# **SCOPING OPINION:**

## **Proposed A47/A11 Thickthorn Junction**

**Case Reference: TR010037**

**March 2018**

Figure Title	Drawing number
Figure 1.1 – Site Location	HE551492-GTY-EGN-000-DR-LX-30001 P02

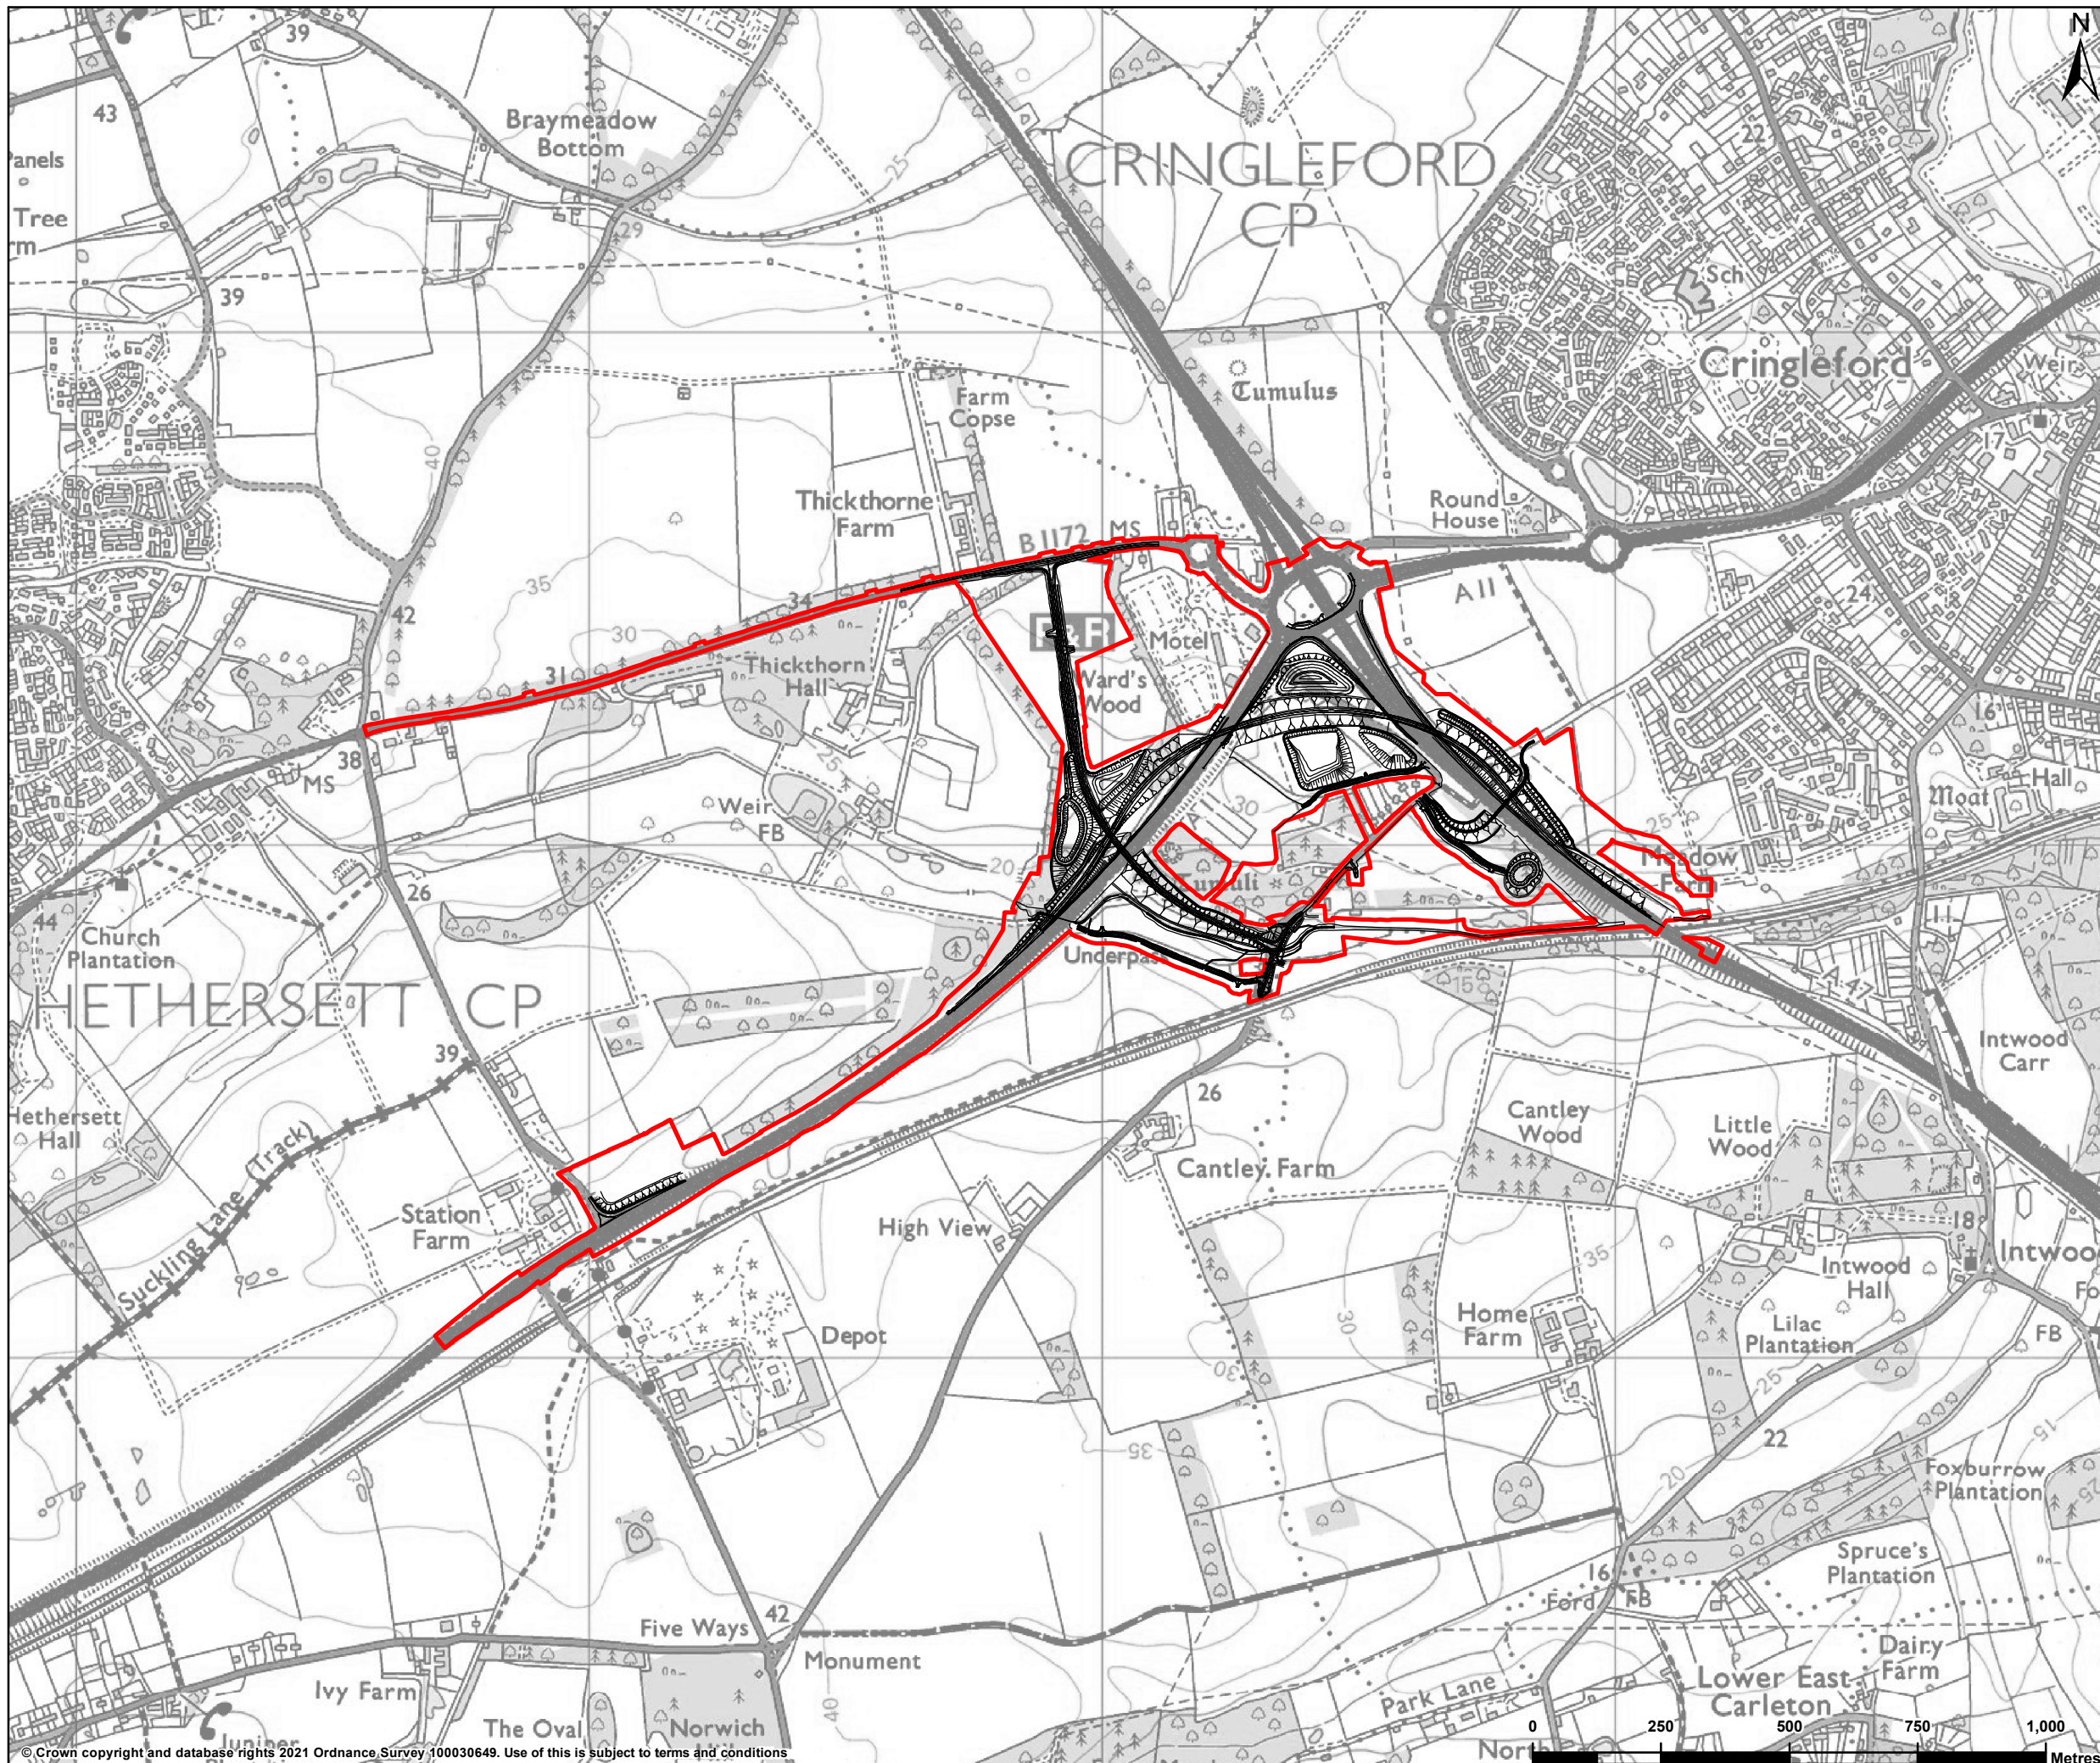
2.3.1 The Scoping Report contains only limited detail, with the main characteristics of the Proposed Development explained in high-level terms. The description of the Proposed Development is unclear and not consistent with what is shown on Figure 1.1 of the Scoping Report. For example, the description provides for two options for the side road strategy (to reconnect Cantley Lane South) and states that these options are collectively referred to as the 'Proposed Scheme', however neither option is presented on Figure 1.1. The description provided omits the other elements of the Proposed Development, such as, for example, the interchange link roads. The information provided on the link roads lacks detail and is confusing.

- 2.3.4 The legend in Figures 1.1 and 3.1 refer to 'Highways England led improvements' (shown in orange) and 'Proposed developer funded improvements' (shown in blue). A footnote included in Figure 3.1, but not in Figure 1.1, states that the development marked in blue is 'a local scheme progressed by developers with South Norfolk District Council'. This suggests that these elements are not included in the DCO application. However the land required for their construction is clearly included in the DCO site boundary (Figure A.1, Appendix A). This further confuses the understanding of what constitutes the Proposed Development.

- 2.3.5 The Inspectorate expects that at the point of application the ES should include a detailed description of the Proposed Development which includes all of the works for which development consent is sought, supported by clear figures. Details of components such as underpass structures, signage, gantries, lighting, drainage features, landscaping and environmental mitigation features have not been provided in the Scoping Report and this information should be provided in the ES.
